15 December 2016

RE: 1 Denison Street, North Sydney - MP 08_0238 MOD 6; MP 08_0238 MOD 7

I refer to your email of 17 November 2016 inviting North Sydney Council to comment on the above proposals and provide any recommended conditions.

B1

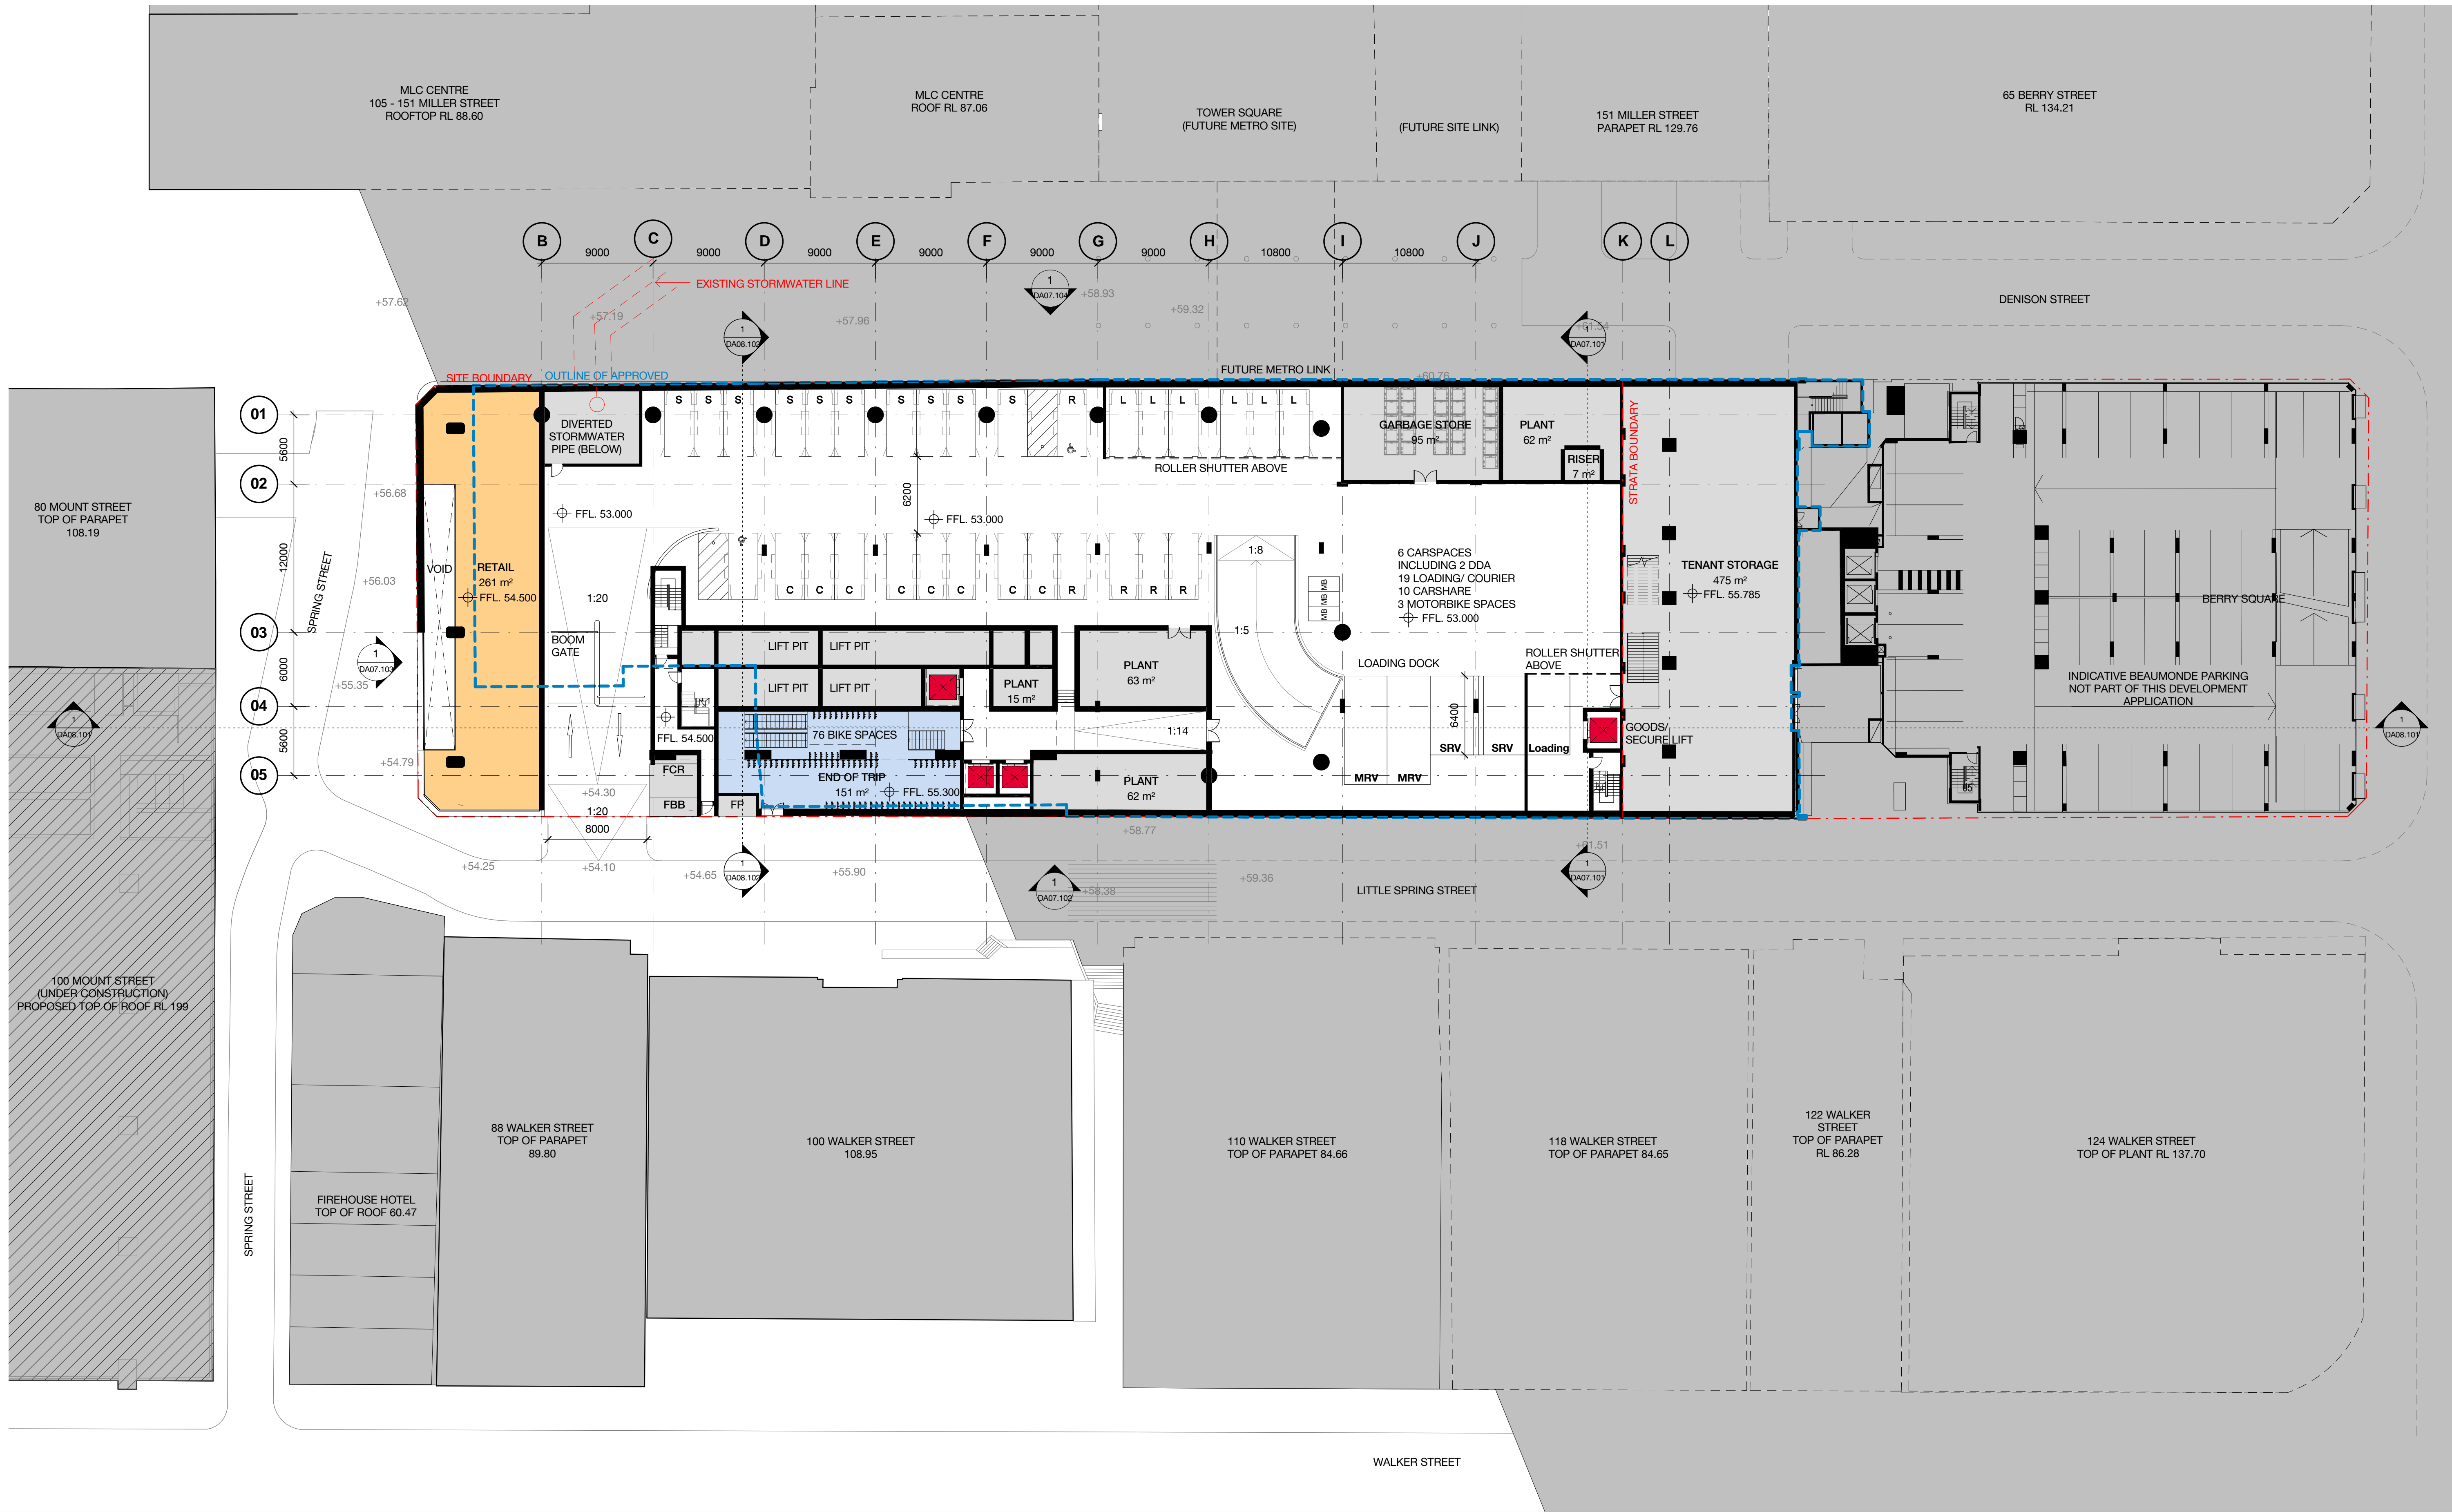
The Proponent shall allocate to Council a minimum of **forty (40)** ~~forty-two (42)~~ car parking spaces **and ?? motorcycle spaces** ~~and twenty-seven (27) motorcycle spaces~~ **commencing** at Basement 1 level of the commercial tower as public parking. Details of the allocation of the required spaces shall be provided to the Department and the Certifying Authority prior to the issue of the relevant Construction Certificate for the Commercial Tower excluding for any initial works.

The new owner now proposes to delete the public parking on site and provide 10 spaces for car share (such as Go Get). The provision of car share spaces does not compensate for the loss of the public metered parking. The public on street parking that will be lost through this development needs to be replaced so that parking is still available for short term visitors and Council does not suffer lost revenue. The proposal to delete the public car park is not supported. The proposed modification with its changes to Denison Street and the public domain will result in the loss of 40 existing on street public parking spaces with 27 of those spaces being metered.

Council does not accept deletion of public parking and seeks minimum of 40 spaces together with motorcycle parking that is to be removed at street level. The public parking would of course be available to visitors to the new commercial building as well as the general public. It may also be possible for the next parking level to be available after hours and on the weekends for additional public parking and part of the area to be managed by Council.
